PLANNING APPLICATION SUBMISSION: REQUEST FOR ADDITIONAL INFORMATION OR FEE

Reference Number: H20-0097-11

Proposal: Erection of five bed house and attached double garage (re-submission of H20-0929-10)

Site Location: Adjoining Askdale Broadgate Road Sutton St James Spalding Lincs

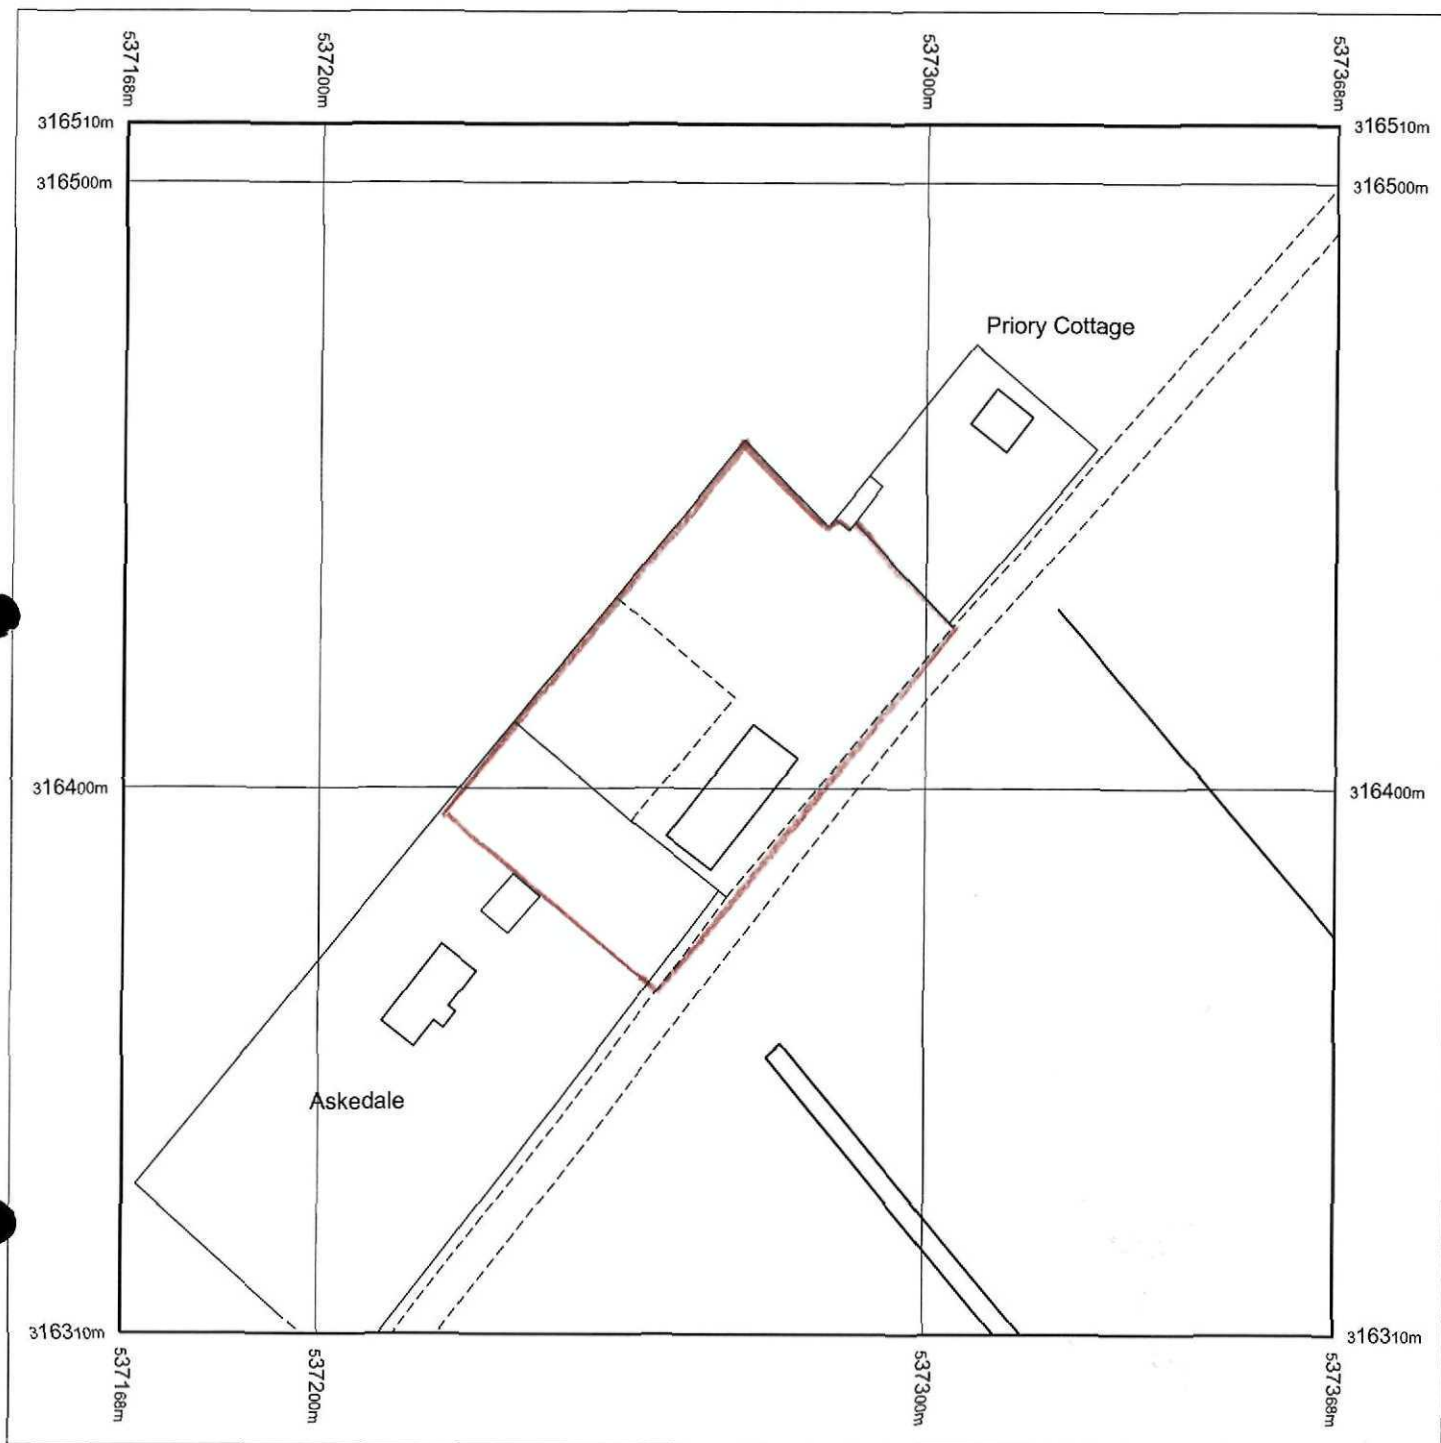
- The elevational and layout drawings differ from the submitted block plan. Is the block plan incorrect or are all the drawings 'handed'?
- In addition, some of the drawings ('Elevation 4' in particular) appear to show the roof, balcony areas, etc, incorrectly. The dining room also appears to be single-storey only and not two-storey as shown on 'Elevation 4'.

Thank you for your letter dated 7th April 2011. Please find attached 2 copies of the revised drawings covering the points in your letter.
